A14
**Cambridge to Huntingdon
improvement scheme**
Development Consent Order Application

Response to ExA's Second Written Questions:

Principal Issue 13 Water Issues

August 2015

Areal Extent of Award Drain/Hilton Brook Model

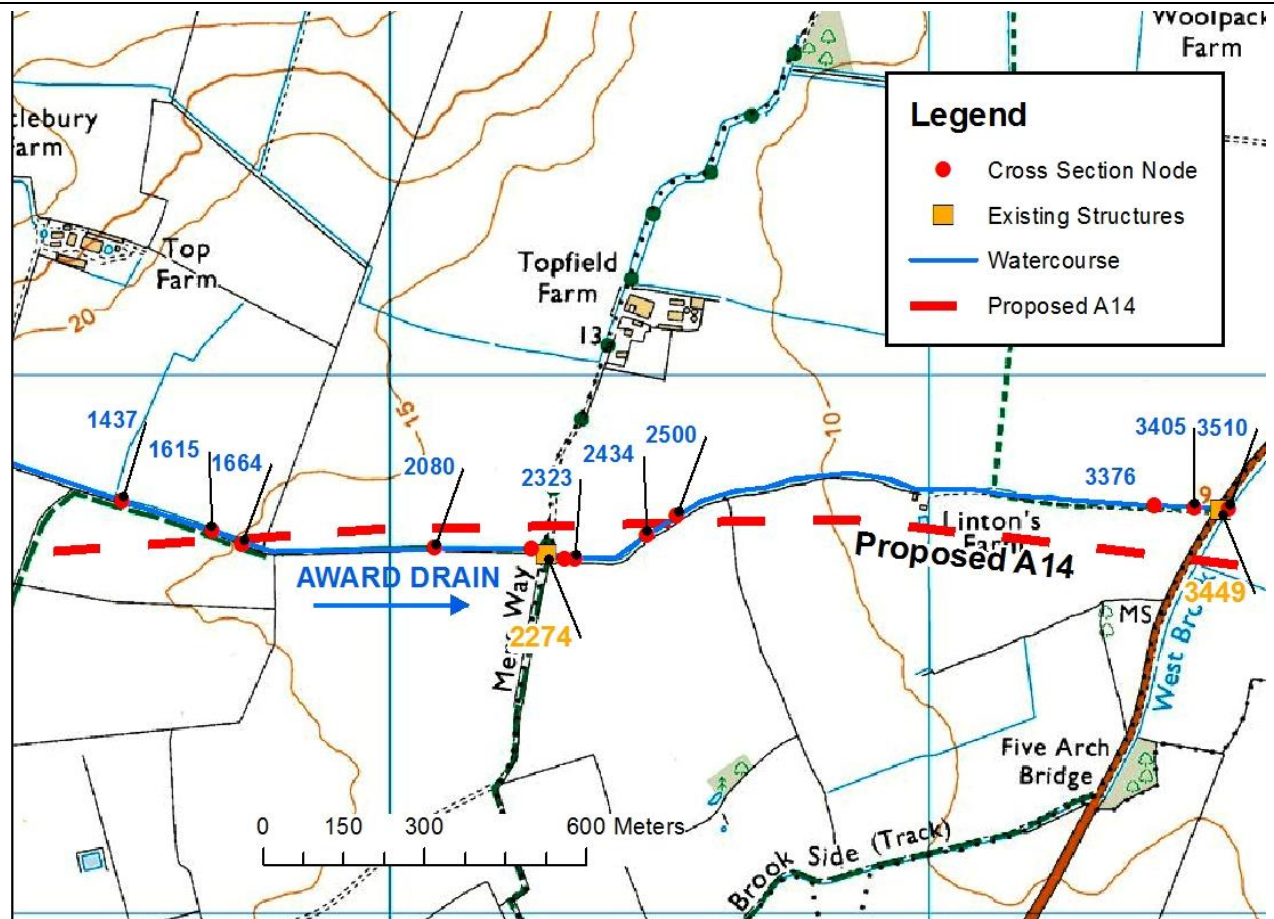
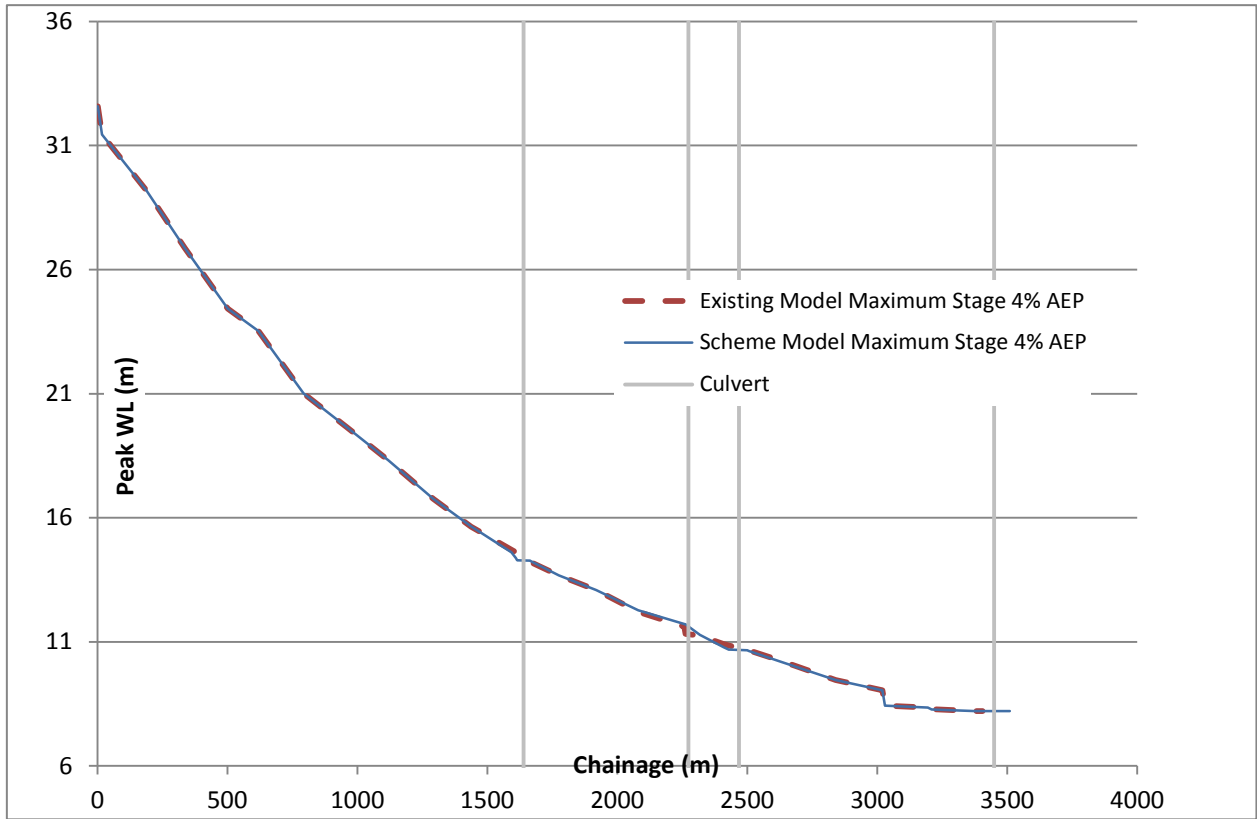
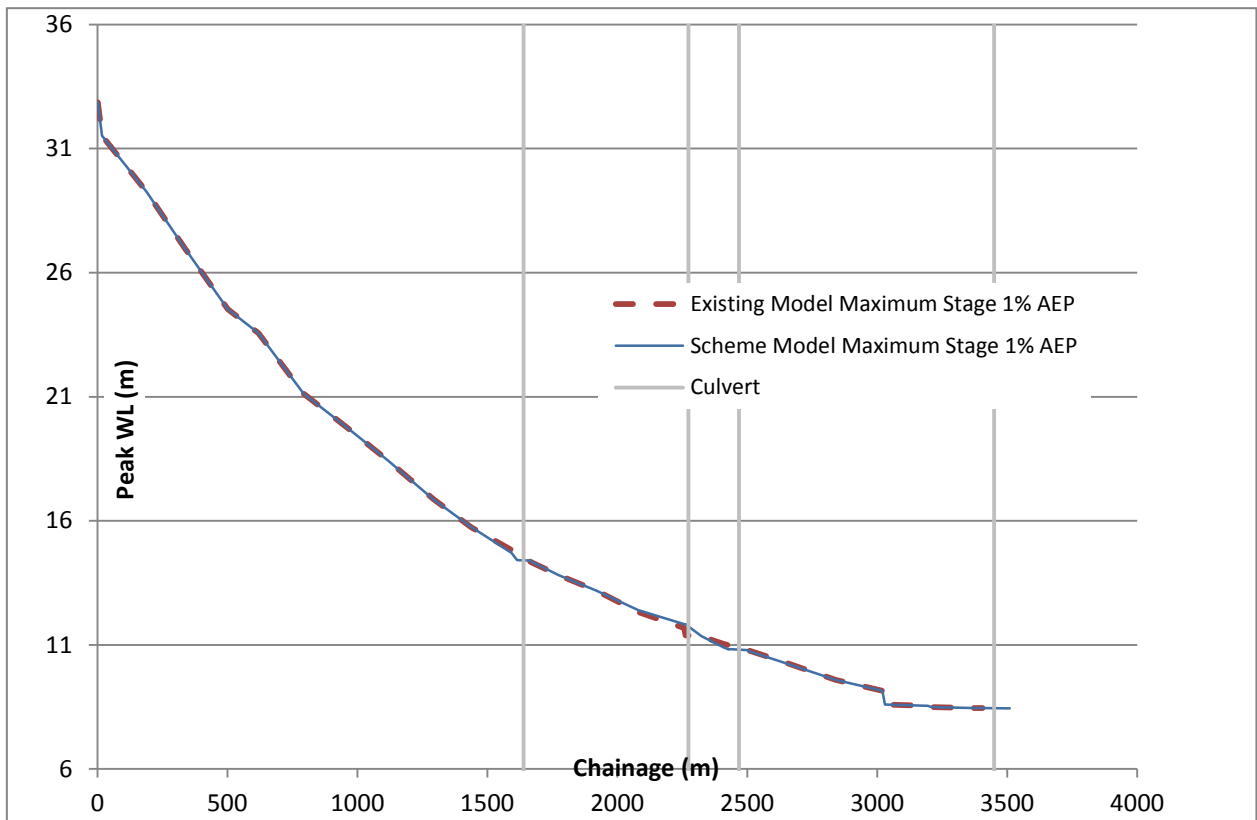
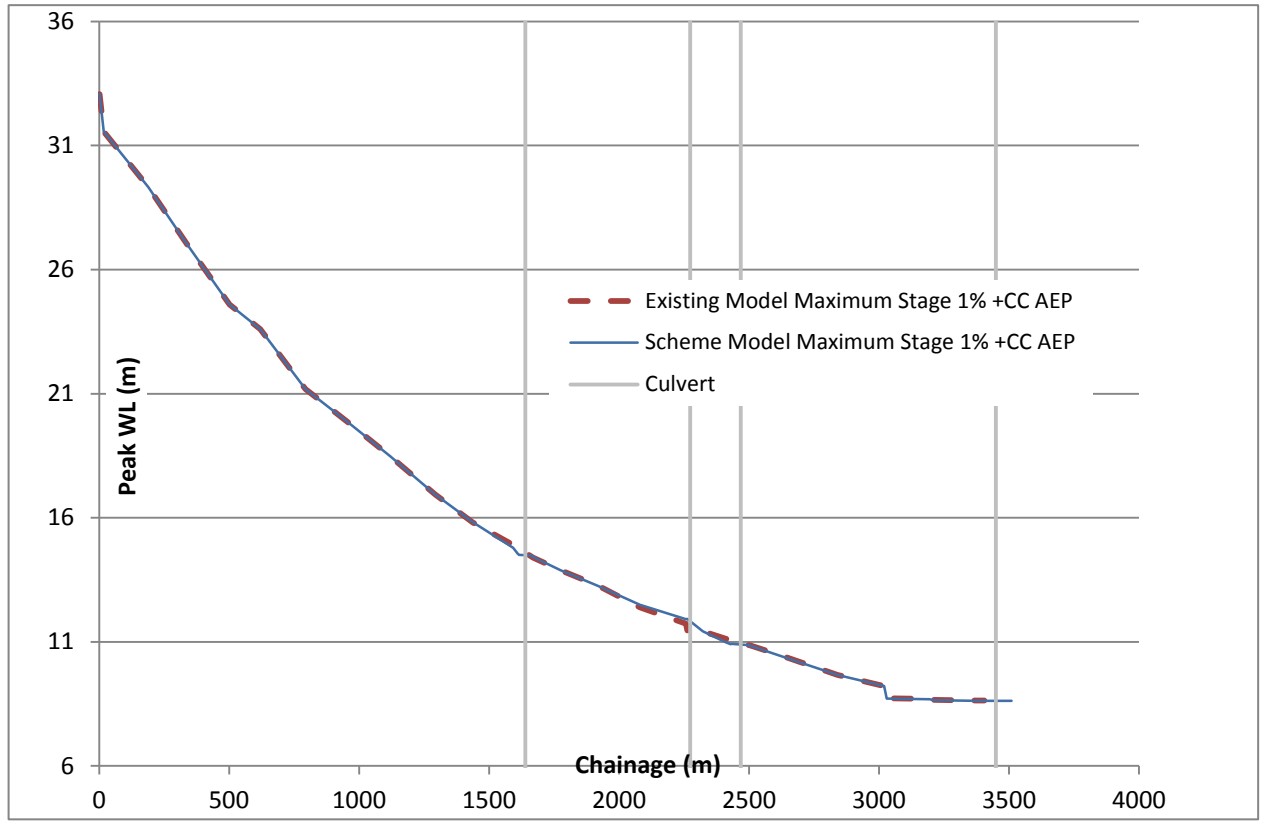
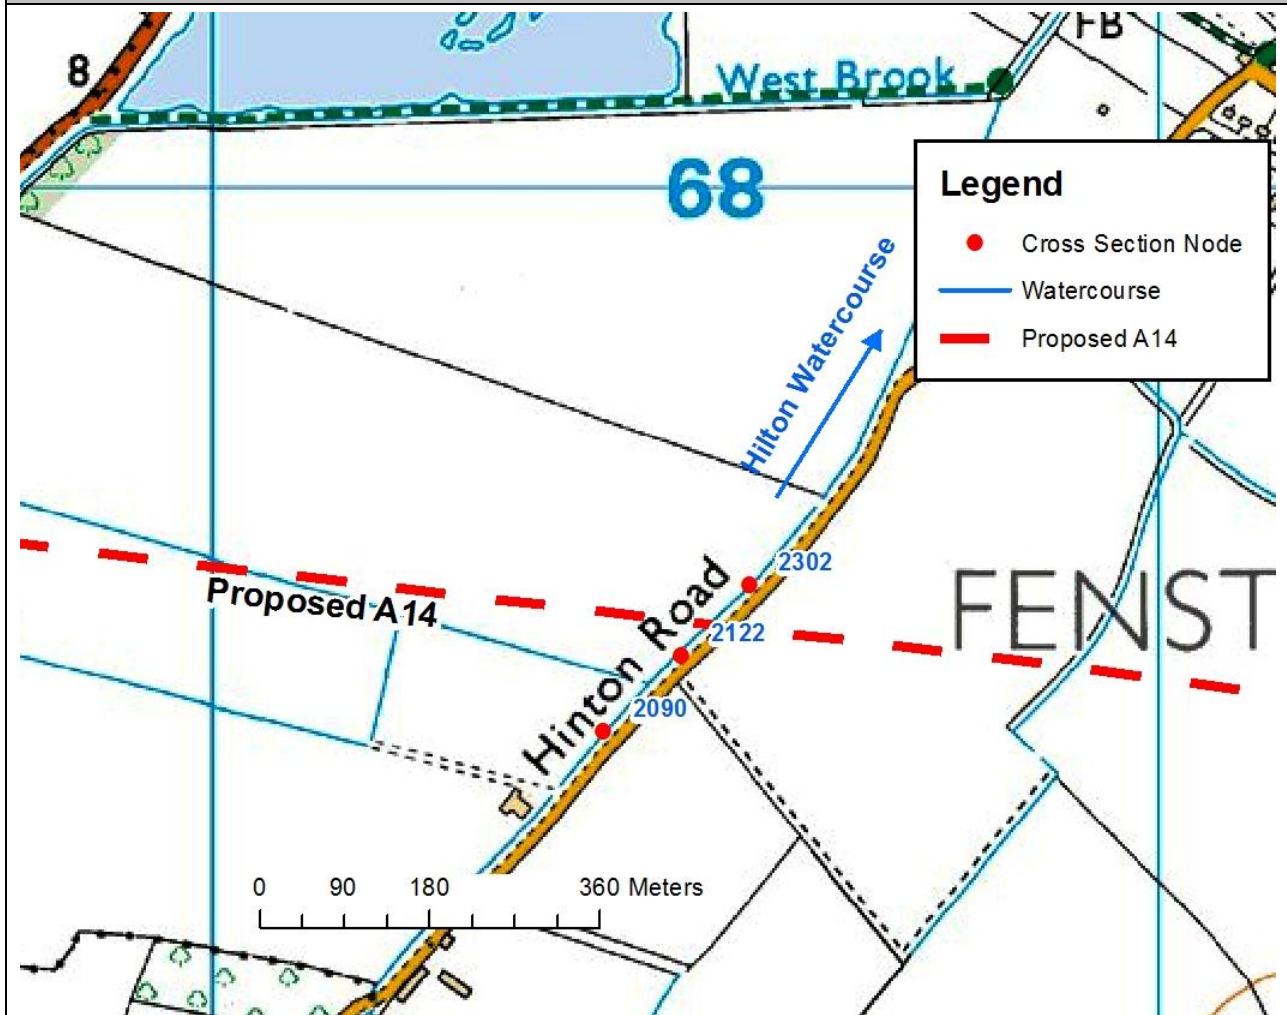
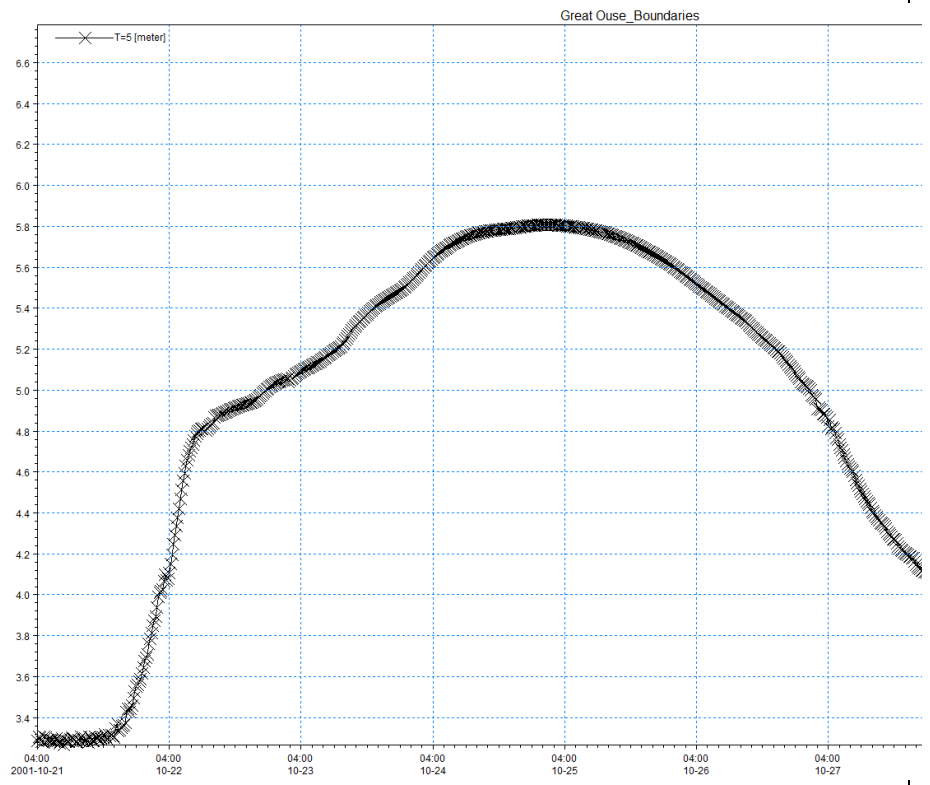
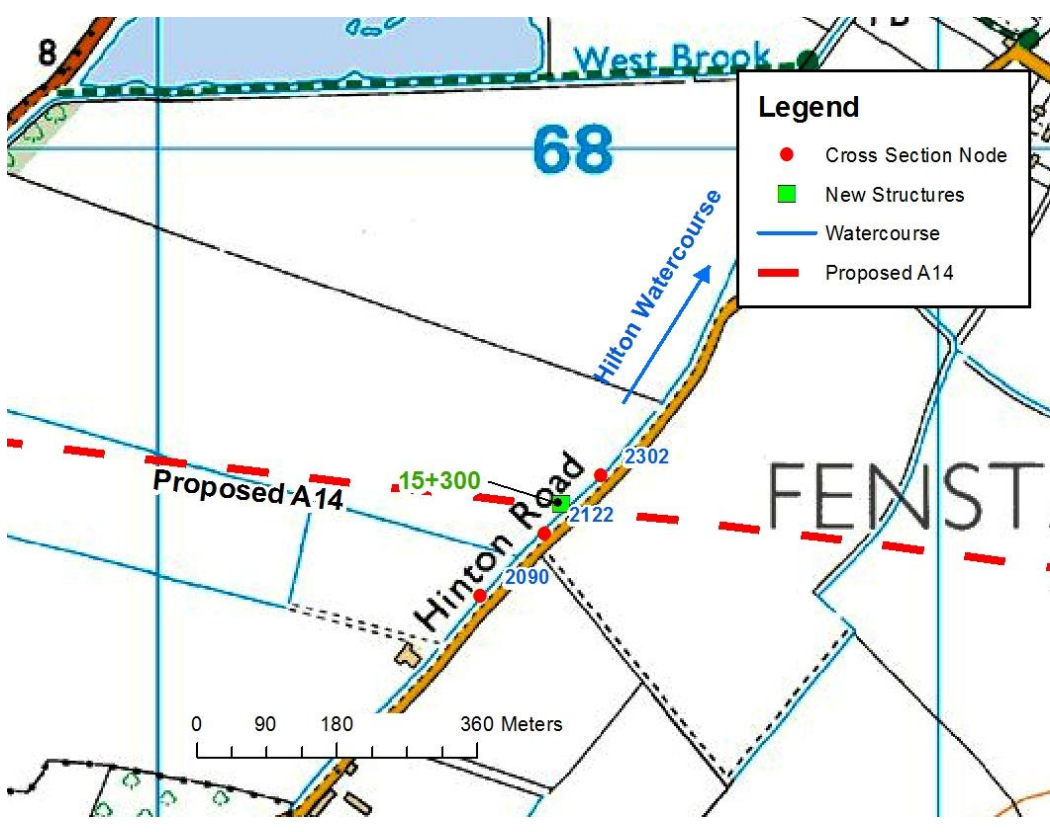
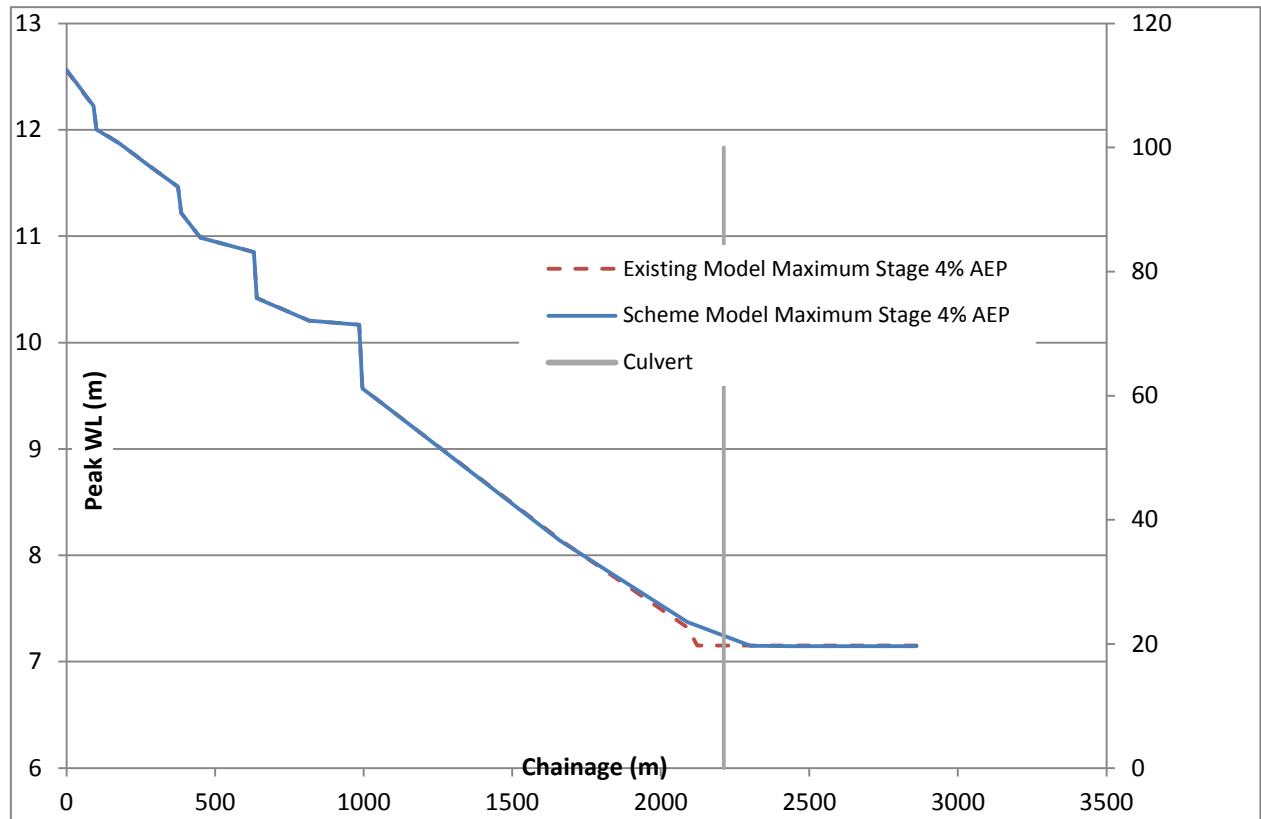
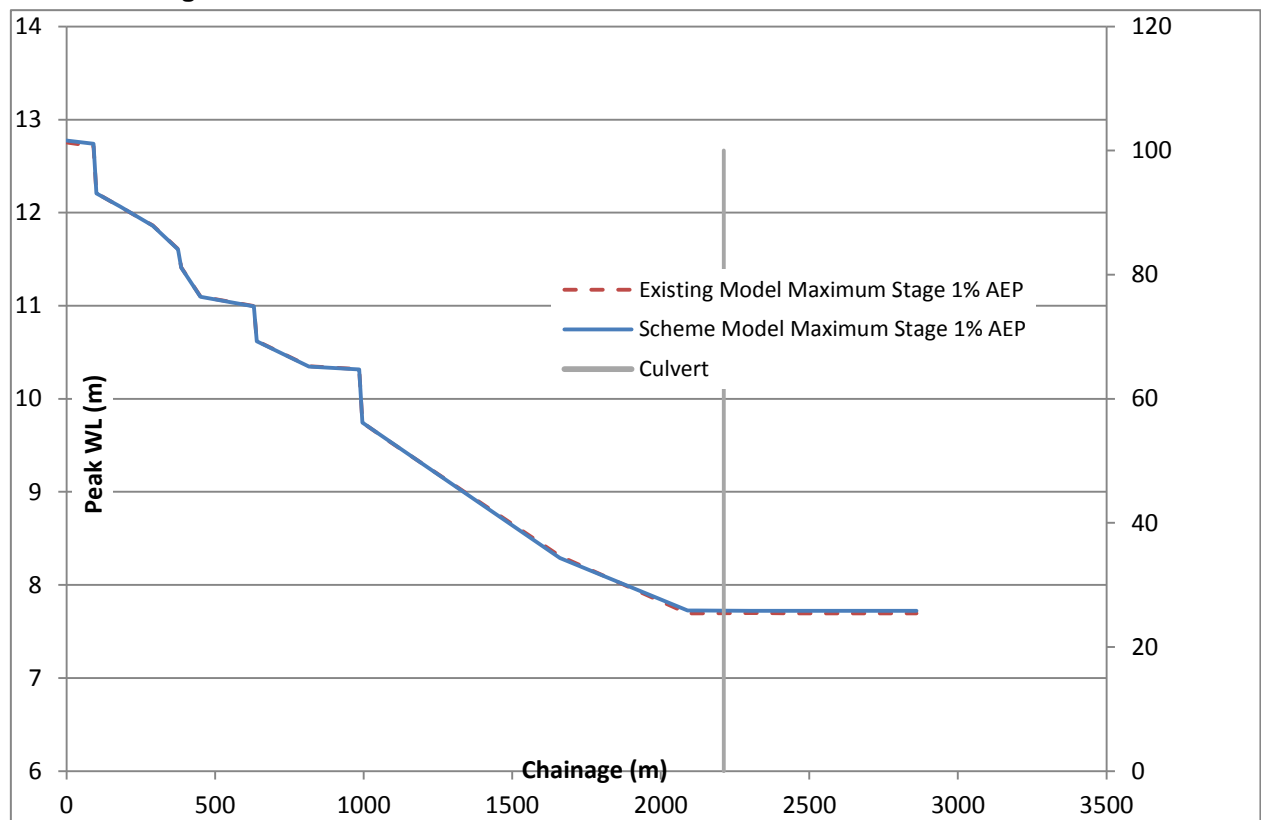
As the 2001 flood event has been said to be the result of blocked culverts and insufficient maintenance, would the scheme increase the number of culverts on the eastern Award Drain? If so, how would the maintenance of the additional culverts be regulated. (REP2-014, para3)

1. The scheme would require the construction of three additional culverts on the Hilton Drain, referred to in section 11 of the *Flood Risk Assessment* (Applicant reference 6.3, Appendix 17.01, PINS reference APP-744) as the Eastern Award Drain. One of the culverts would convey the Drain under the new A14 mainline. Two additional short culverts would be required to convey the Drain under access tracks. These culverts are shown on *General Arrangement Sheet 11* (Applicant reference HE/A14/EX/11 PINS reference APP-774).

2. Maintenance of Highways England's operational assets in the region of the scheme is currently managed under a system of Asset Maintenance and Operational Requirements (AMOR) which are secured under contract with the asset support contractor. This is an outcome focussed approach to maintenance of drainage and other assets which seeks to match the maintenance supplied to the maintenance needs, including the sensitivity of a location to flooding, of any given asset. This accords with industry led sector guidance published as part of the Highways Maintenance Efficiency Programme. Contractor performance against the AMOR is kept under review and sanctions apply for poor performance.

3. As an ordinary watercourse the local drainage authority, Huntingdonshire District Council (HDC), is responsible for the regulation of the proper flow of water through the Eastern Award Drain in accordance with the Land Drainage Act 1991. As such HDC has powers (pursuant to section 25A) to require persons in control of the watercourse to remedy any impediment to the flow of water and these powers would not be affected by the DCO.
